Appeal Decision

Appeal Ref: APP/T2350/W/23/3333973

Land to the south of Chatburn Old Road, Chatburn, Clitheroe

- The appeal is made under section 78 of the Town and Country Planning Act 1990 (as amended) against a refusal for Technical Design Consent.
 - The appeal is made by Mr Ronald Jackson against the decision of Ribble Valley Borough Council.
 - The application Ref is 3/2022/0500.
The development proposed is Technical Details Consent application following on from Permission in Principle for land to the south of Chatburn Old Road, Chatburn. Site adjoining rear boundaries of Crow Trees Brow, High Beech House and recently approved/developed Hare Hill Croft.
-

PL 30

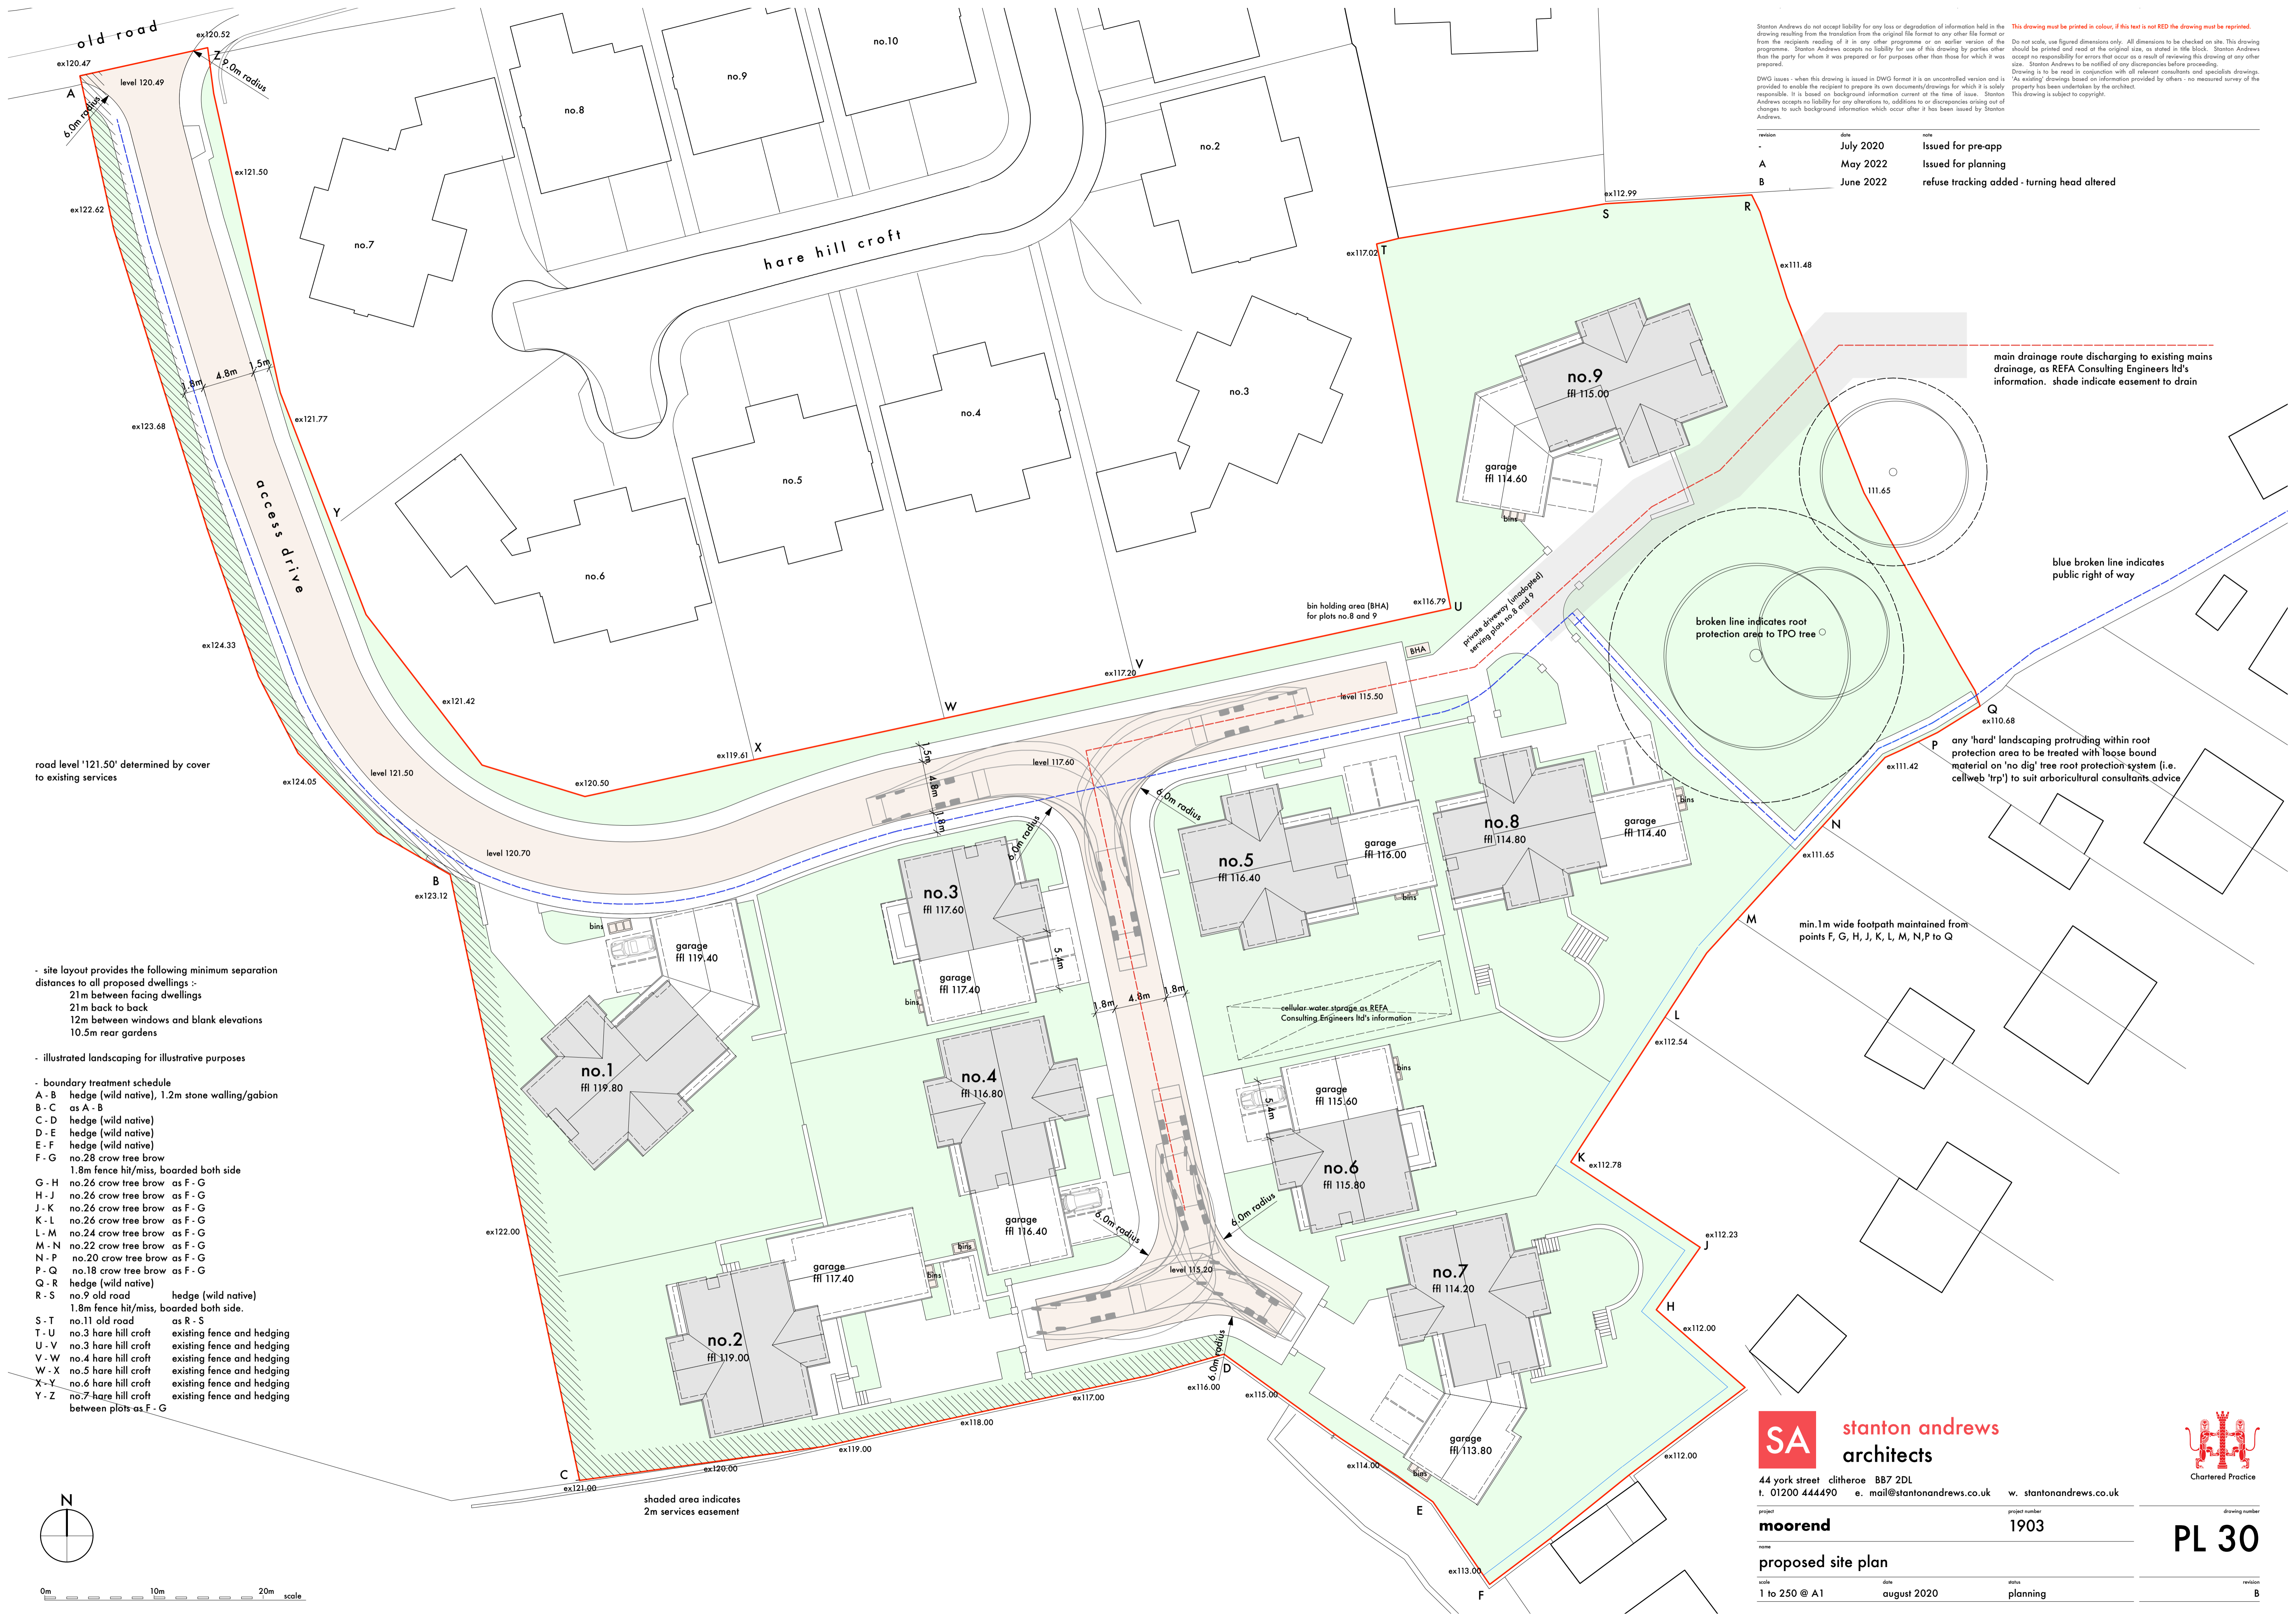
36. The proposed dwelling at Plot 07 ('No 7') would be located adjacent to, and orientated to face a considerable section of the southerly flank boundary for the rear garden of No 26. At the Hearing, the main parties agreed that there are no

38. The proposed boundary between these properties would comprise a taller fence than the one that exists. Even so, there would be an appreciable difference in finished floor levels between No 7 and No 26, with the proposed dwelling being on higher ground. Consequently, the rear windows for the ground and first floor accommodation at No 7 would be higher than the top of the proposed boundary fence.

39. The shared boundary between No 7 and No 26 is irregular. As such, the separation between the rear elevation of No 7 and the boundary with No 26 varies between about 10.8m at the closest point to just over 14m at the furthest point.
